Shivesh Singh - Scottish Hospital Redevelopment: MP 10_0016

From: Frank Costigan <Frank.Costigan@iag.com.au>
To: "'plan_comment@planning.nsw.gov.au'" <plan_comment@planning.nsw.gov.au>
Date: 13/12/2010 7:26 PM
Subject: Scottish Hospital Redevelopment: MP 10_0016

30-34 Stephen Street
Paddington NSW 2021

STEPHEN STREET ELEVATION

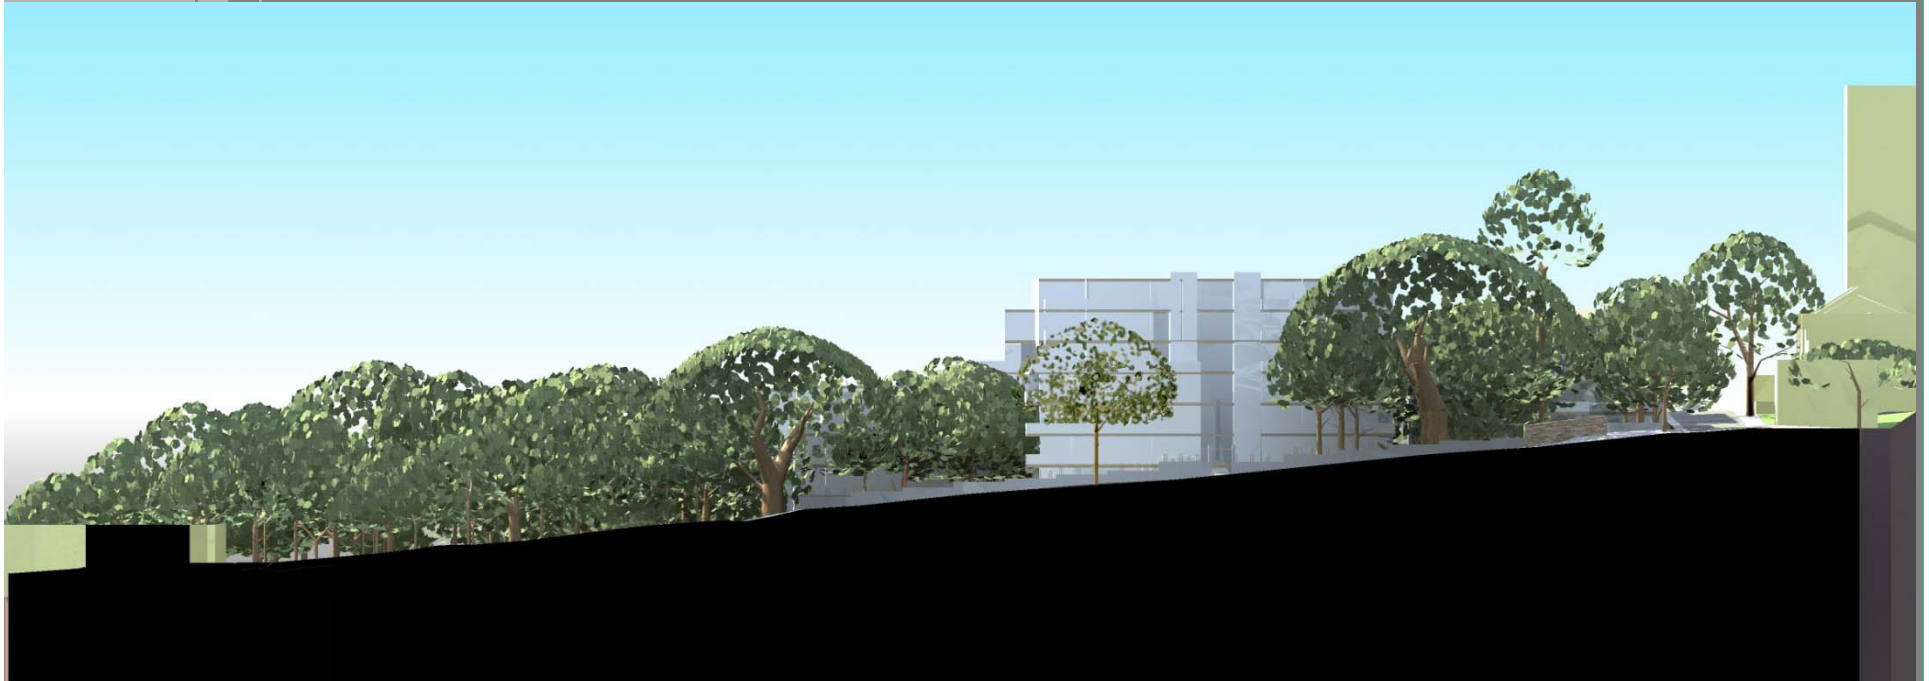
Whilst most of the redevelopment makes sense, I am **OPPOSED** to the Stephen Street Residential Aged Care Facility (RACF) and ILU building that are proposed to be situated towards the eastern boundary of the site fronting Stephen Street. There are currently no buildings on this area of the Scottish Hospital site and therefore this means new buildings and the removal of most of the trees.

- **Visual impact will be negative:** The new buildings and loss of trees will have a significant negative impact on the visual beauty of Stephen Street. Paddington is already very crowded and the new buildings will be an eye-sore compared to the current lovely outlook that is captured by the open space and trees. I do not believe the redevelopment should include new buildings but rather be "re-development" of existing buildings.

- **Loss of natural vegetation:** I am concerned about the number of trees that will be removed to make way for these new buildings. The Paddington area is already over-crowded and trees/natural space & light are rare. To remove more trees to make way for further buildings would have a significant negative impact on the local residents. I would prefer all trees along Stephen Street be retained.

VIEW 4: GLEN ST / STEPHEN ST

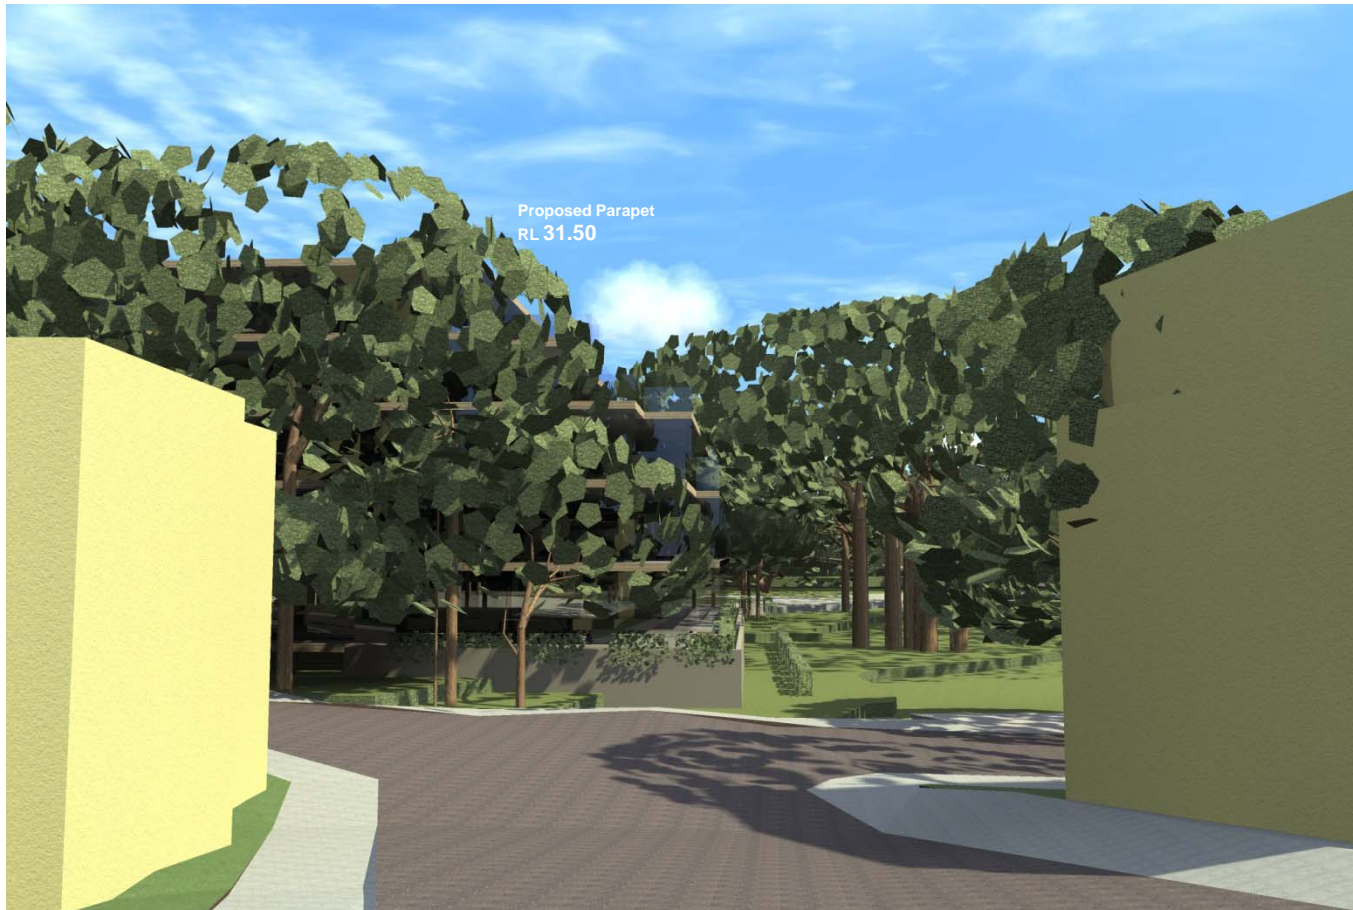
In addition I am **OPPOSED** to the planned new vehicle access to be built on Stephen Street close to where Glen Street intersects with Stephen Street.

- **Increased activity in Stephen Street:** The southern end of Stephen Street is very quiet, the fact that there is a "No Through Road" sign at the entrance to Stephen Street keeps traffic to a minimum and noise levels are incredibly low. The most significant noise is that of the birds in the trees that are located on the site. Erecting a number of new buildings along Stephen Street would change this and make Stephen Street a much more substantial thorough-fare.
